Application Ref:		3/2025/0648		 Ribble Valley Borough Council www.ribblevalley.gov.uk
Date Inspected:	N/A	Site Notice:	N/A	
Officer:	EP			
DELEGATED ITEM FILE REPORT:				APPROVED

Development Description:	Certificate of Lawfulness for proposed single-storey rear extension.
Site Address/Location:	Bramley Farm House, Clerk Hill Road, Sabden BB7 9FQ.

SHEET: PROPOSED FLOOR PLAN
AND ELEVATIONS

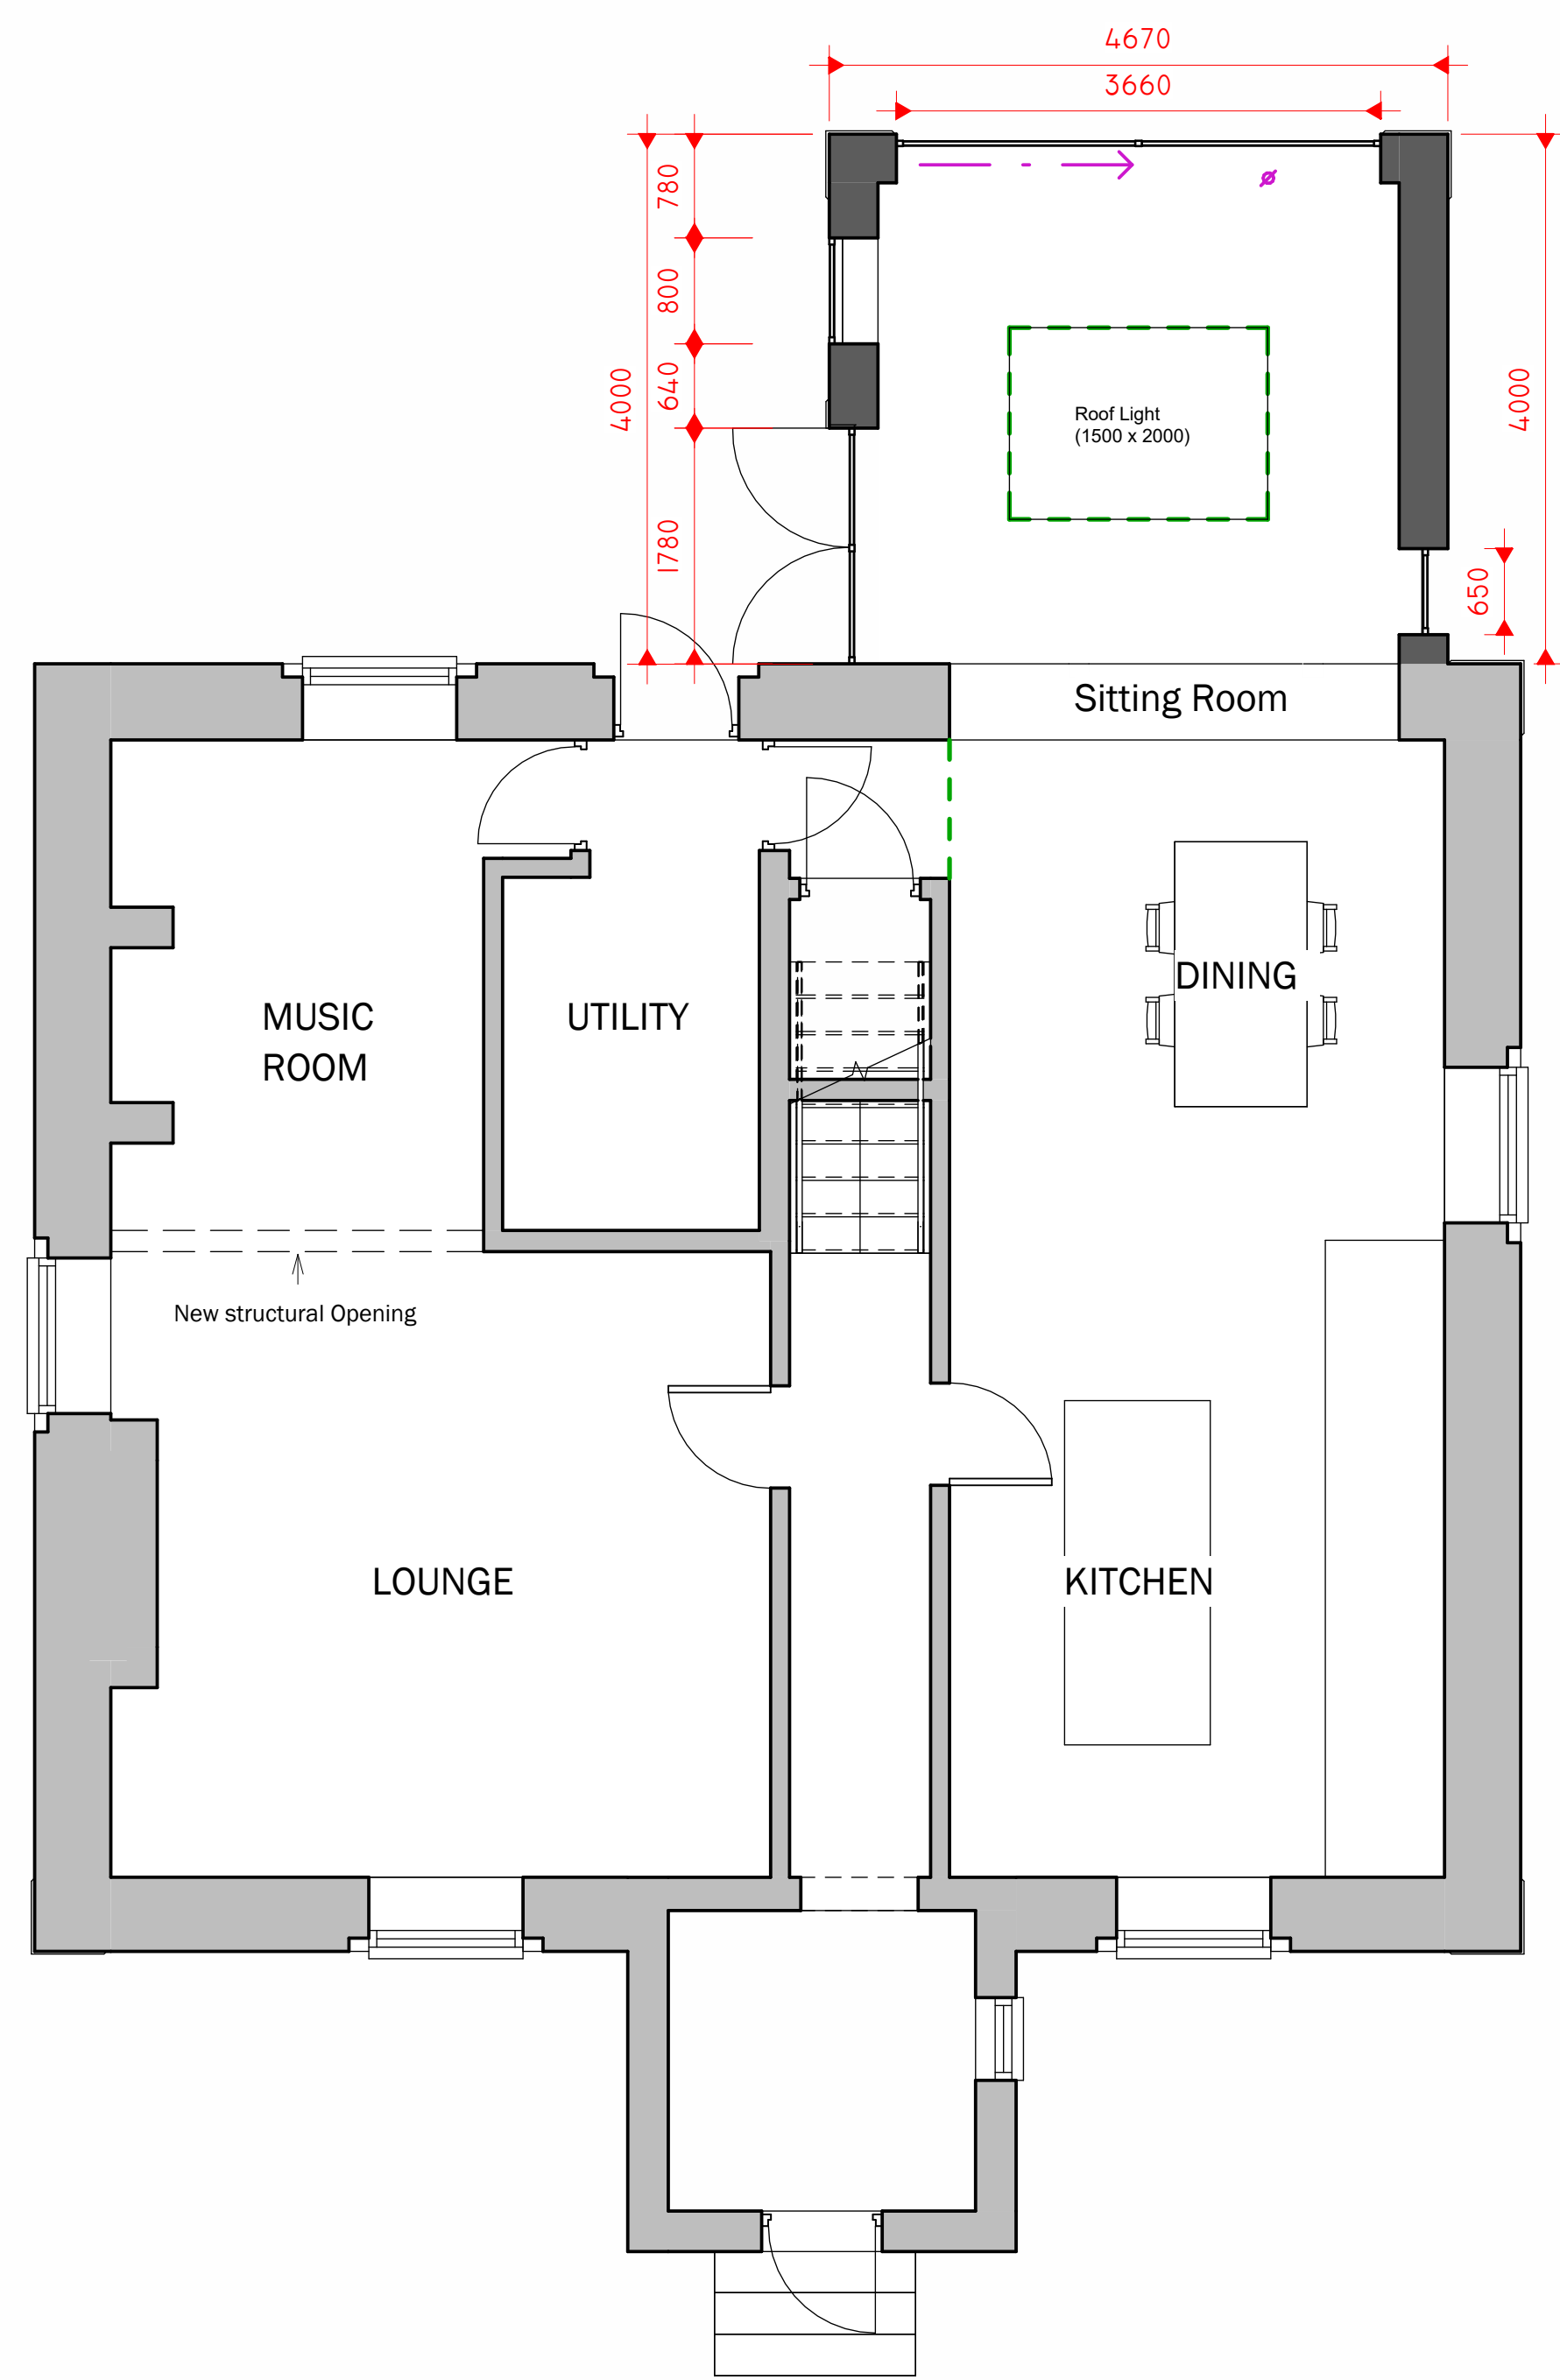
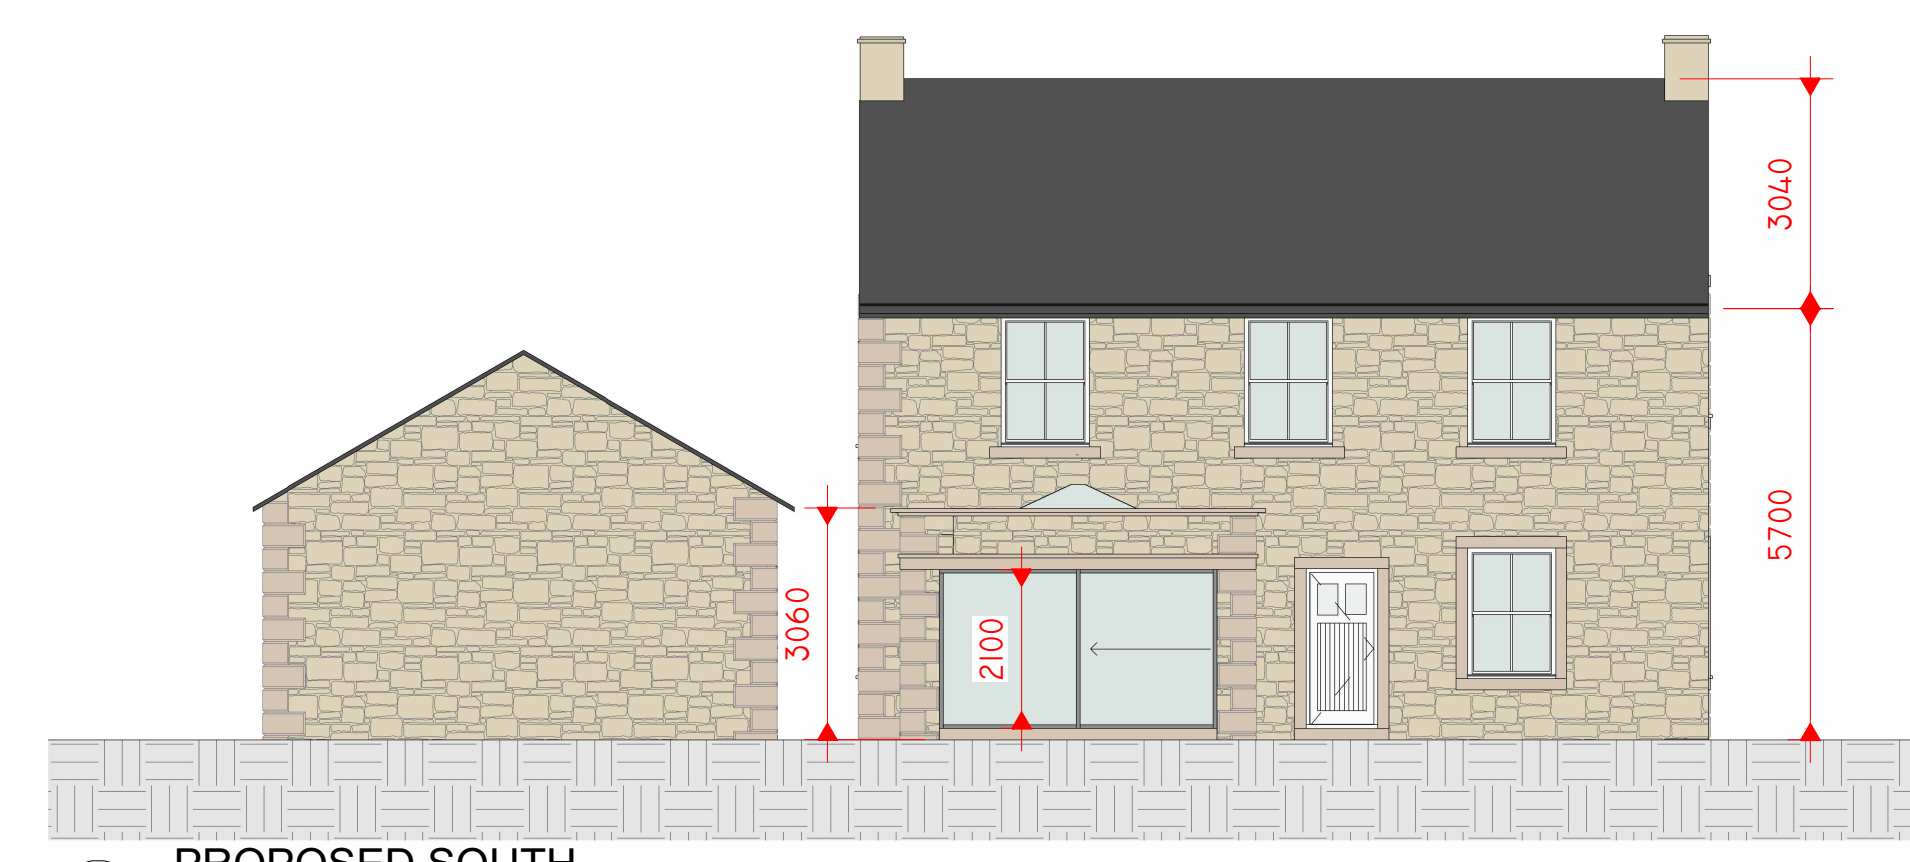
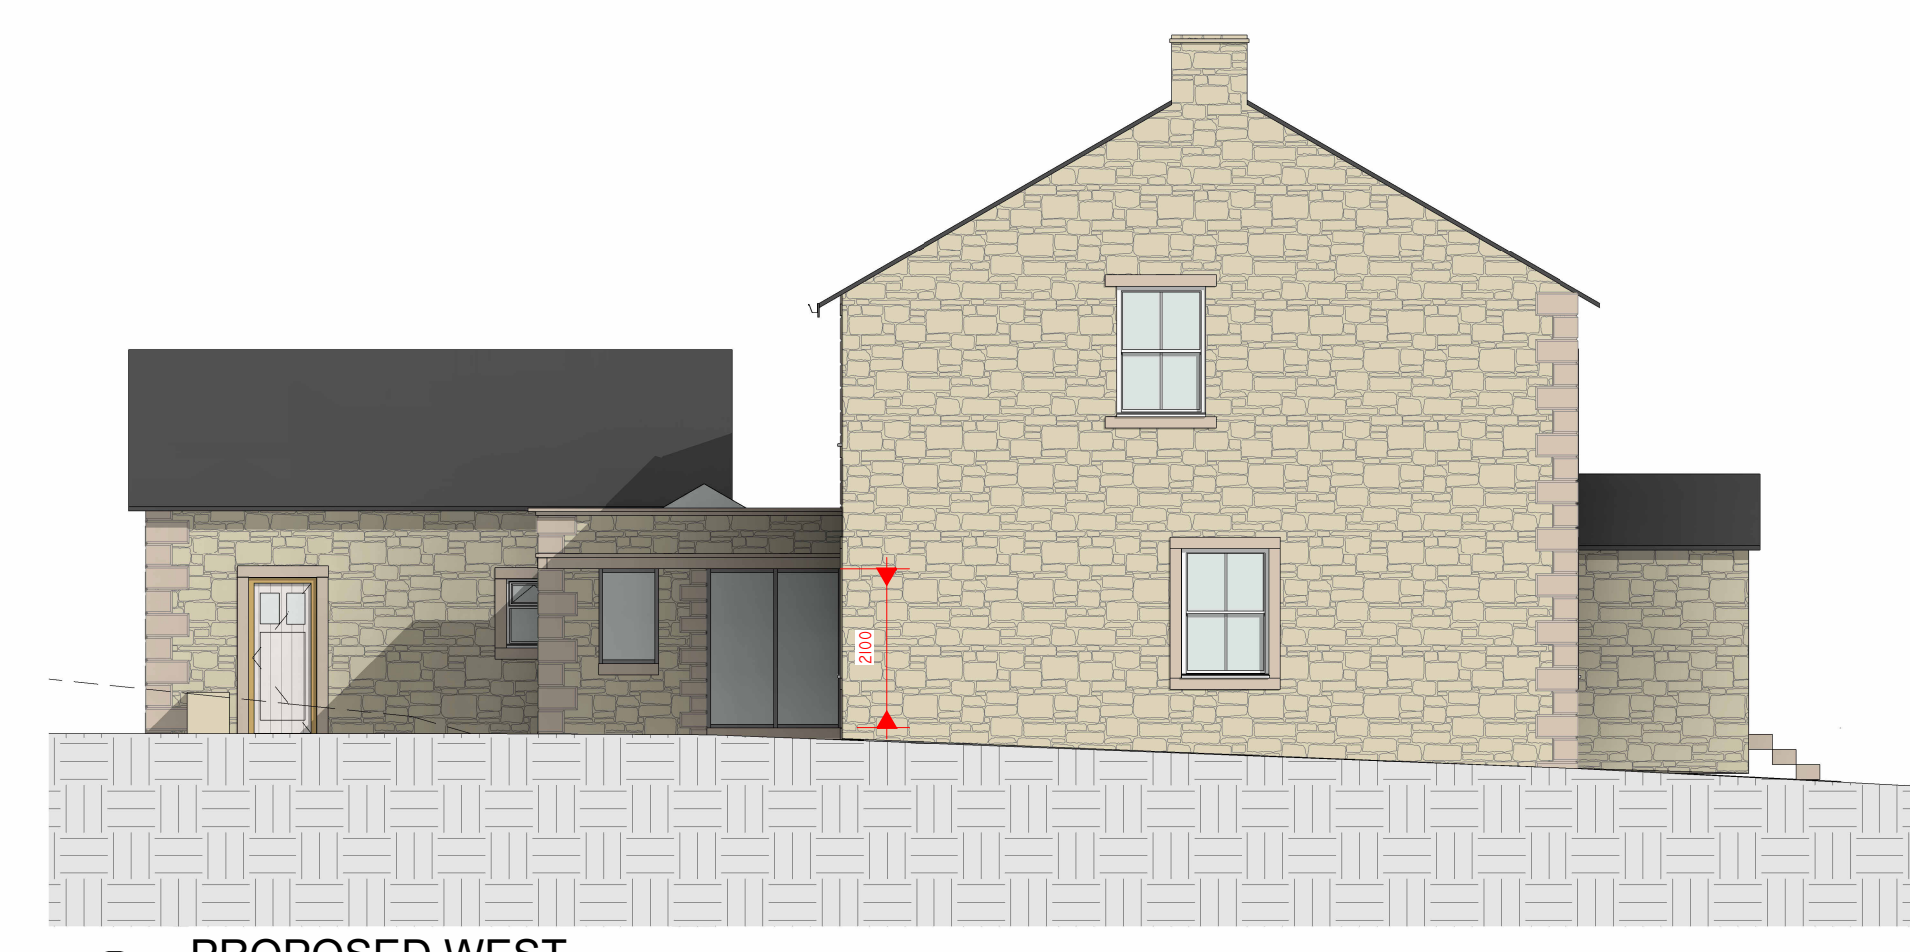
For the avoidance of doubt, the proposal is assessed against amended plans dated 09/09/2025, as per the agents request.

The single storey extension would not exceed 50% of the total area of curtilage of the property.

The height of the proposed single storey extension would not exceed the height of the existing dwelling.

The height of the eaves of the proposed extension would not exceed the height of the eaves of the existing dwellinghouse.

The proposed single storey extension would not extend beyond a wall which forms the principal elevation of the original dwellinghouse or fronts a highway and forms a side elevation of the original dwellinghouse.

The proposed rear extension does not extend beyond the rear elevation of the original dwelling by more than 4m.

The proposed extension would be single storey.

The proposed single storey extension will not exceed 3 metres in height to the eaves.

The proposed extension does not have a side projection.

The proposed single storey extension would not consist of or include any of the above criteria.

The proposed works do constitute permitted development under The Town and Country Planning (General Permitted Development) (England) Order 2015 Schedule 2, Part 1, Class A subject to the external facing material being of similar appearance to the existing dwelling.
